PORTLAND MAINE

August 8, 2005

RE: Proposed Hadley's Way Subdivision
Application ID #2005-0167
CBL: 248 B006001

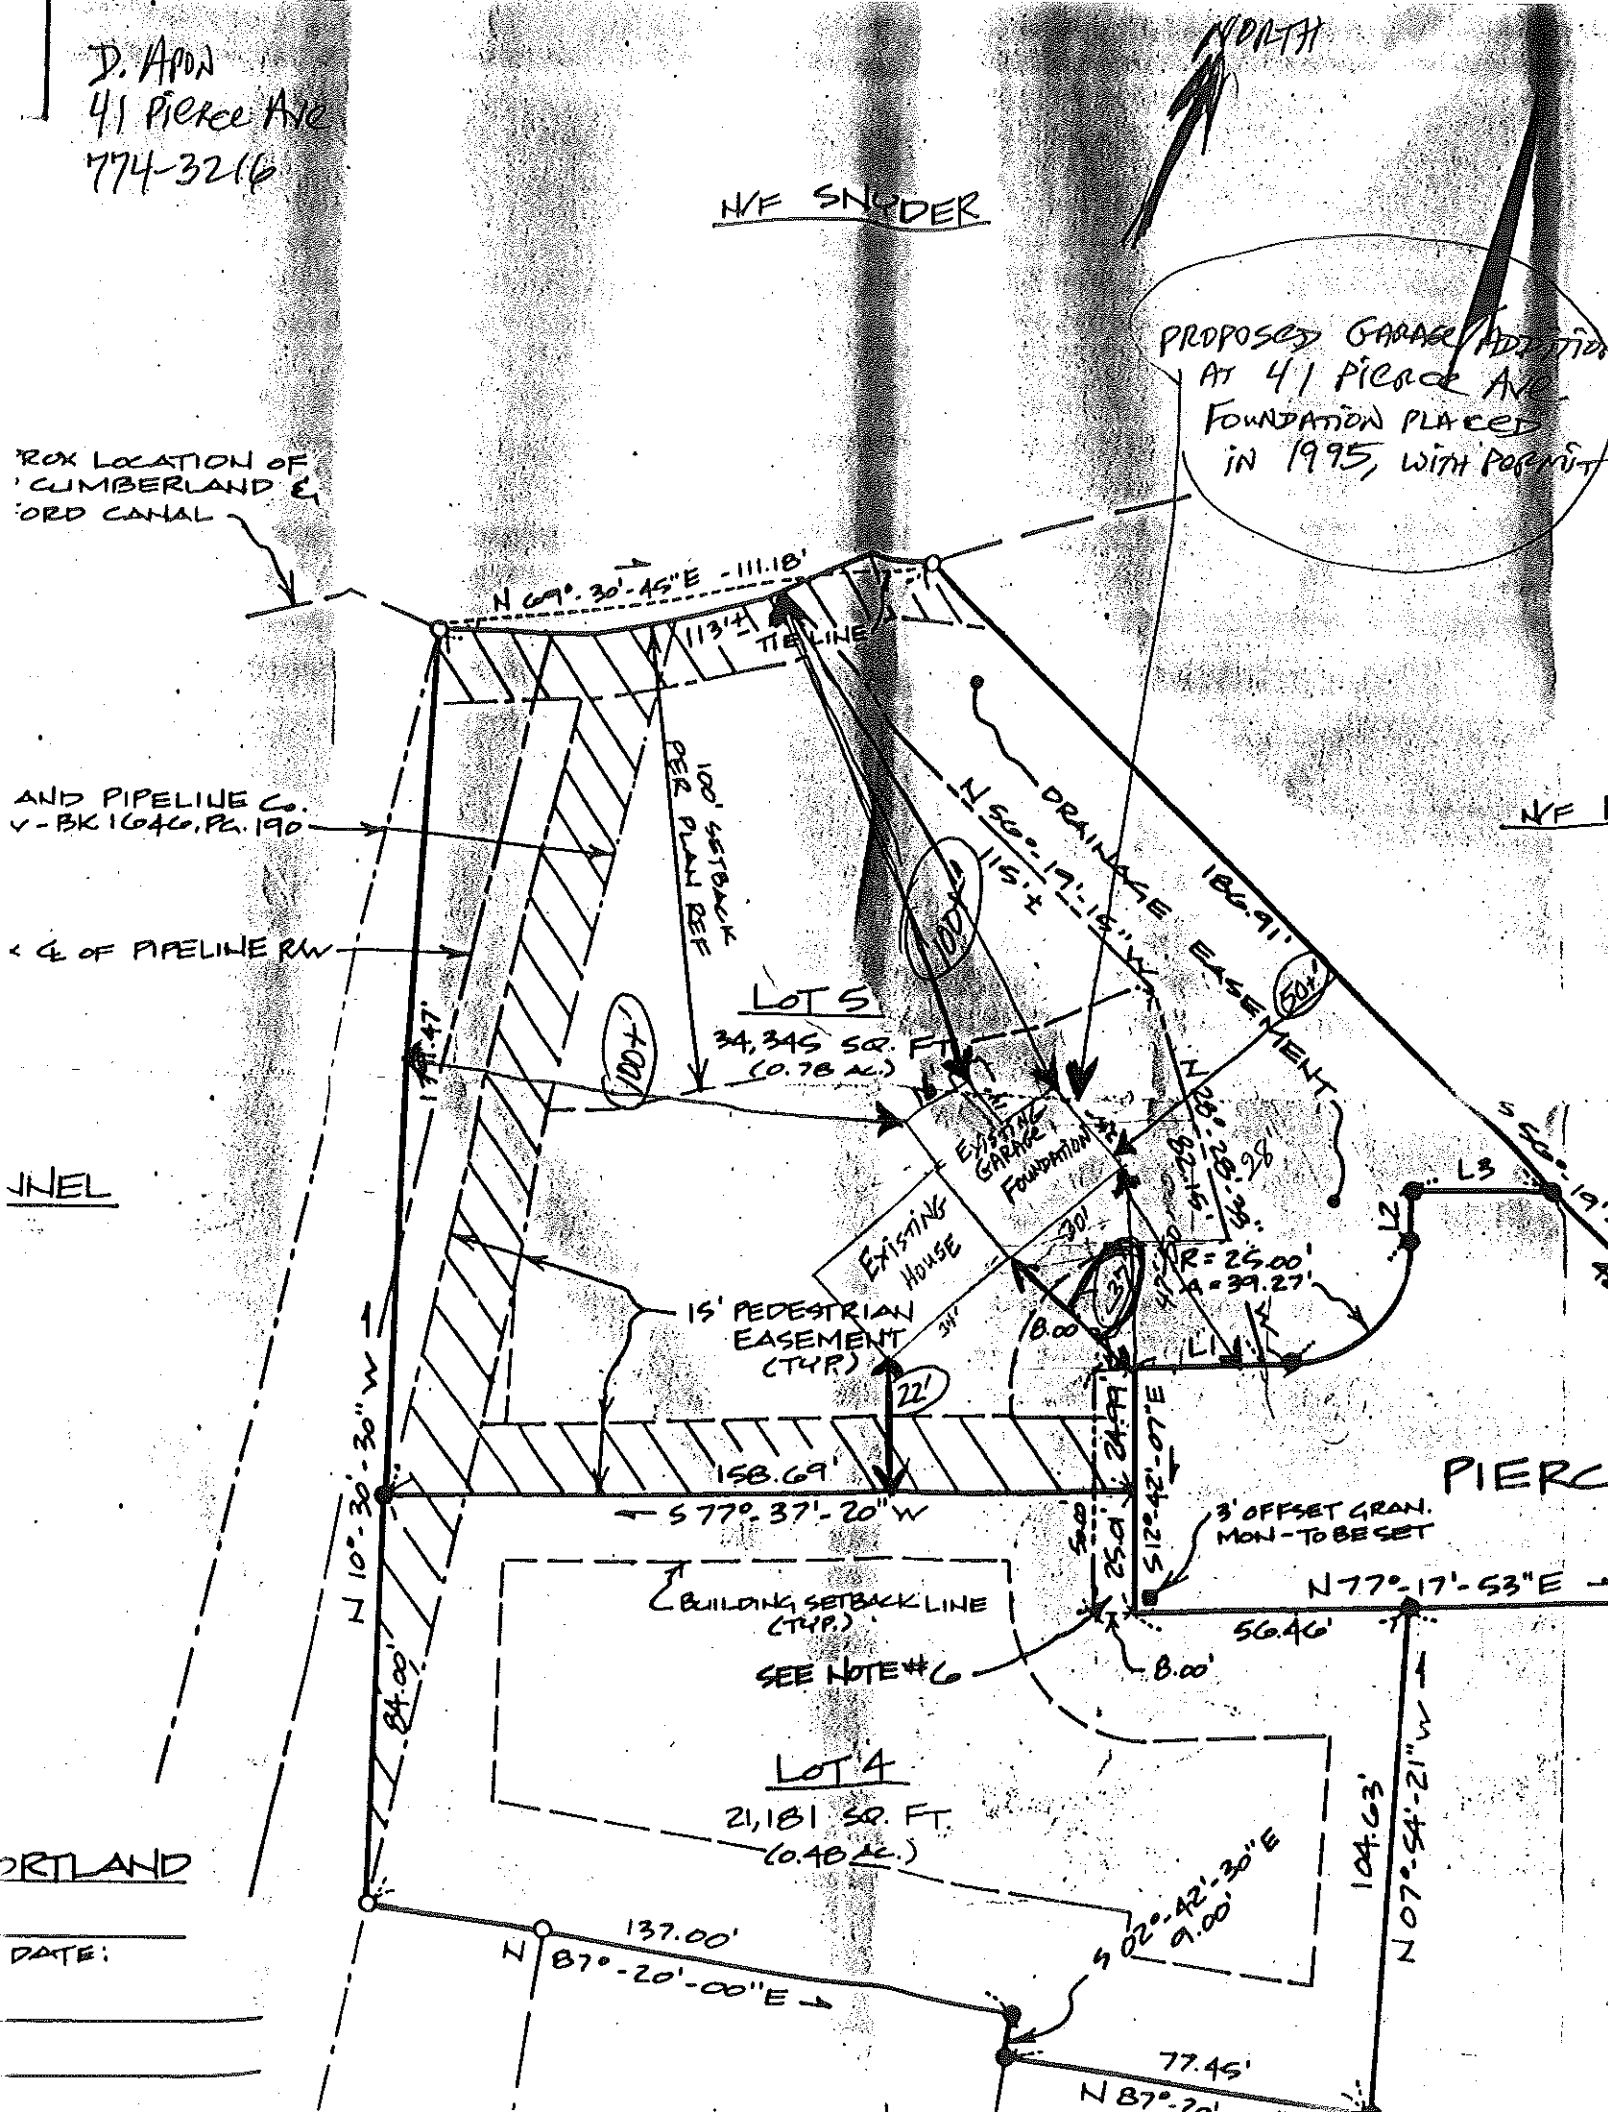
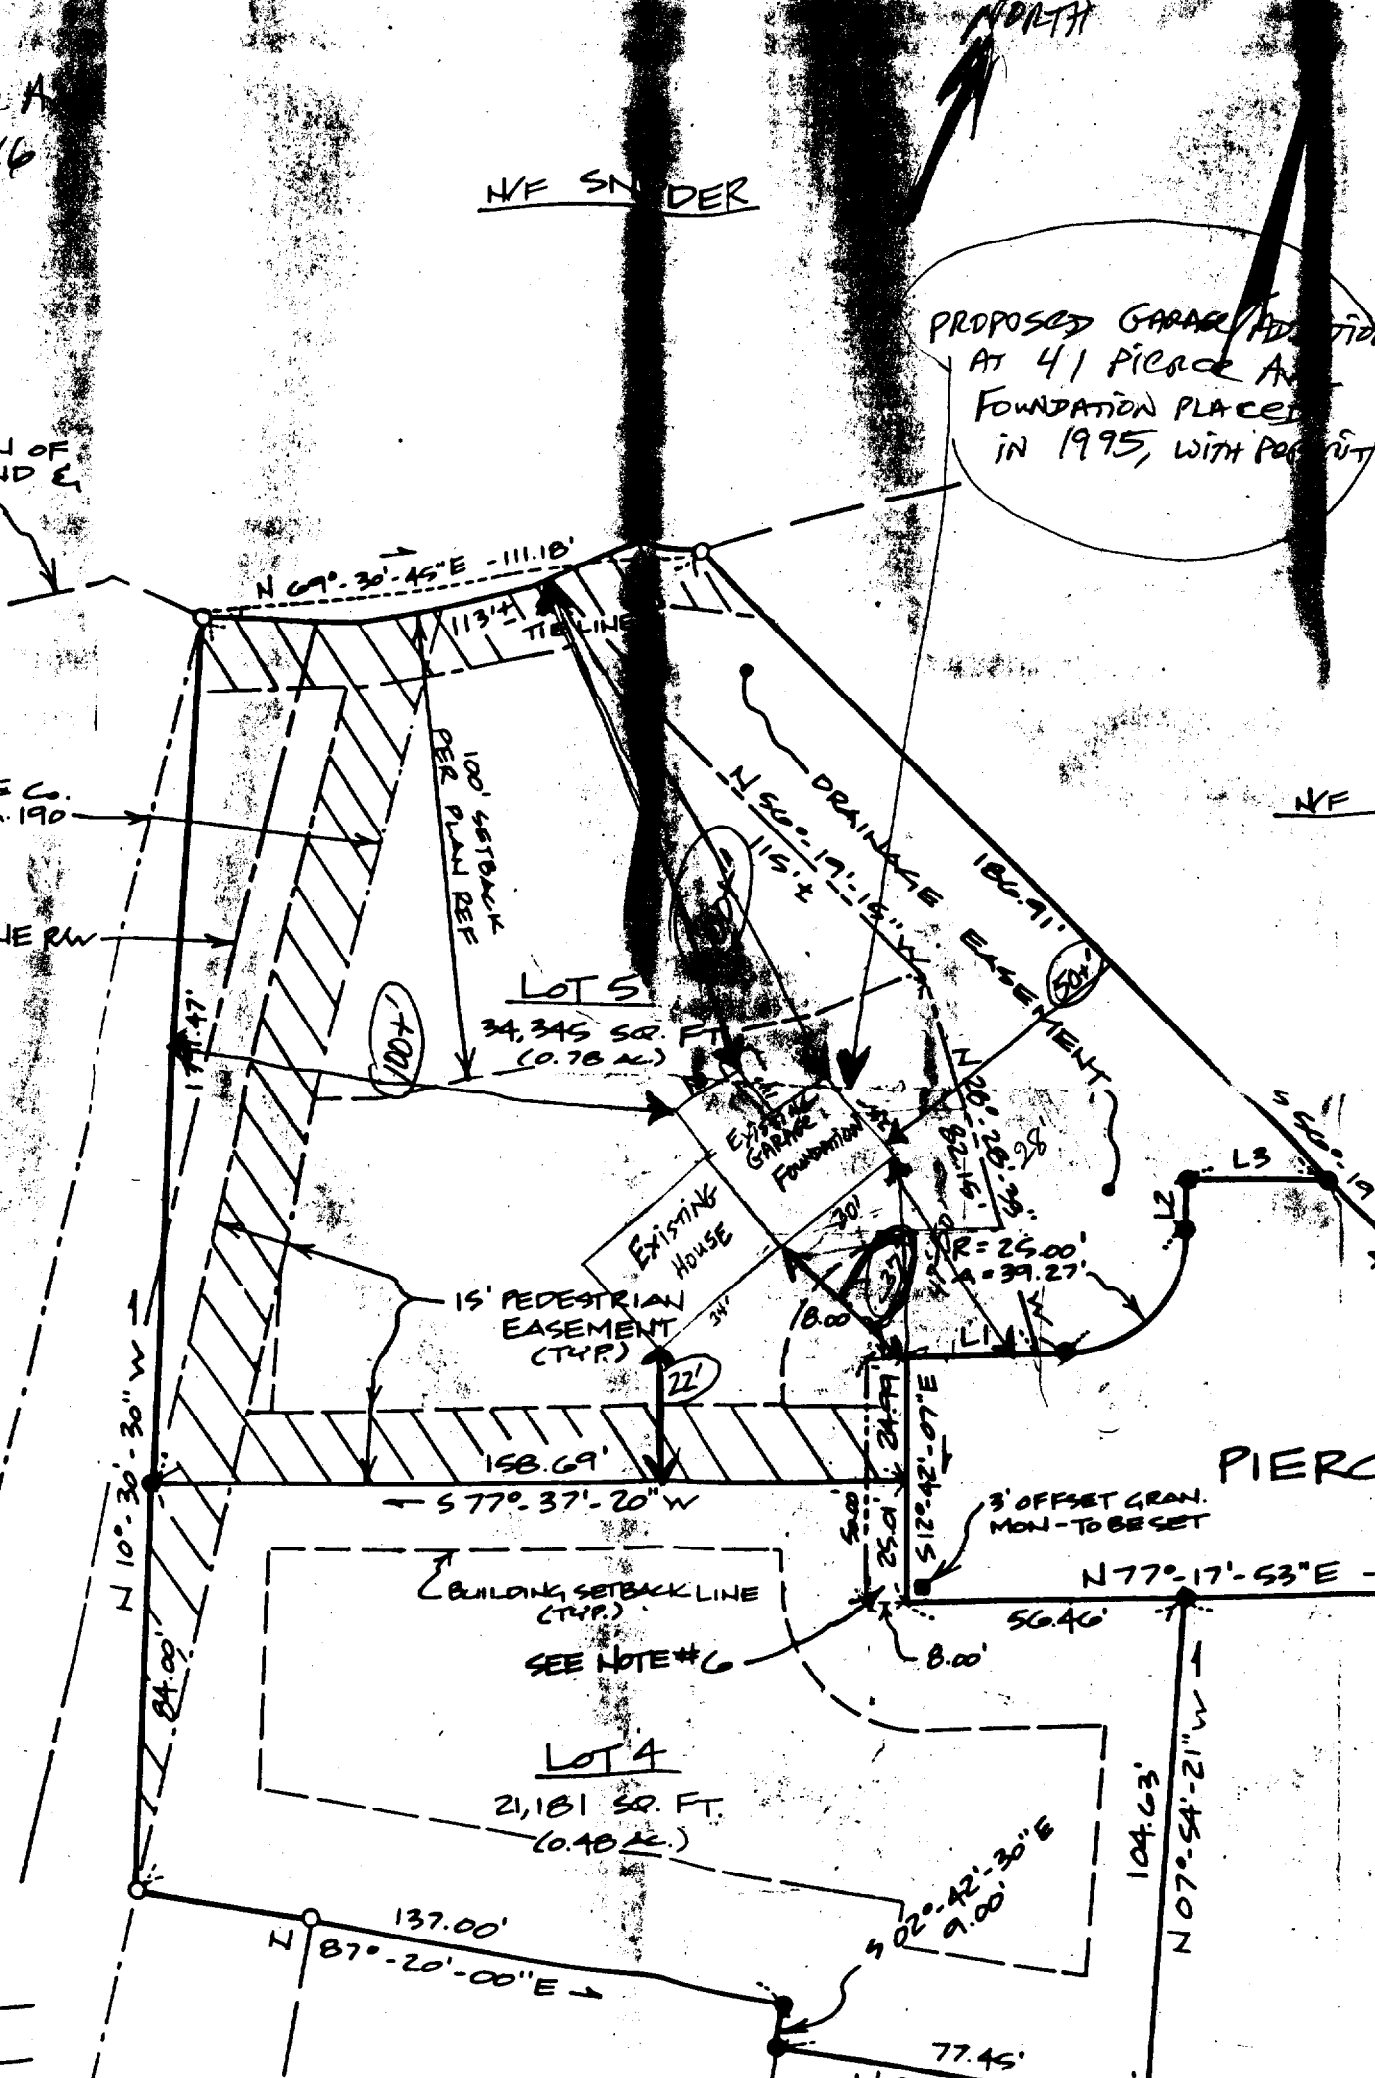
The subject site appears to be encumbered by easements to the Portland Water District and Portland Pipeline Co. The plans do not indicate whether these easements are existing or proposed. The subdivision plan proposes crossing and or grading to these easements. The applicant should provide copies of all easement that encumber the property and a narrative describing the project's conformance with these easements.

Just as hypothetical house footprints have been shown on lots 1-4, so should such a footprint be indicated on lot 5.
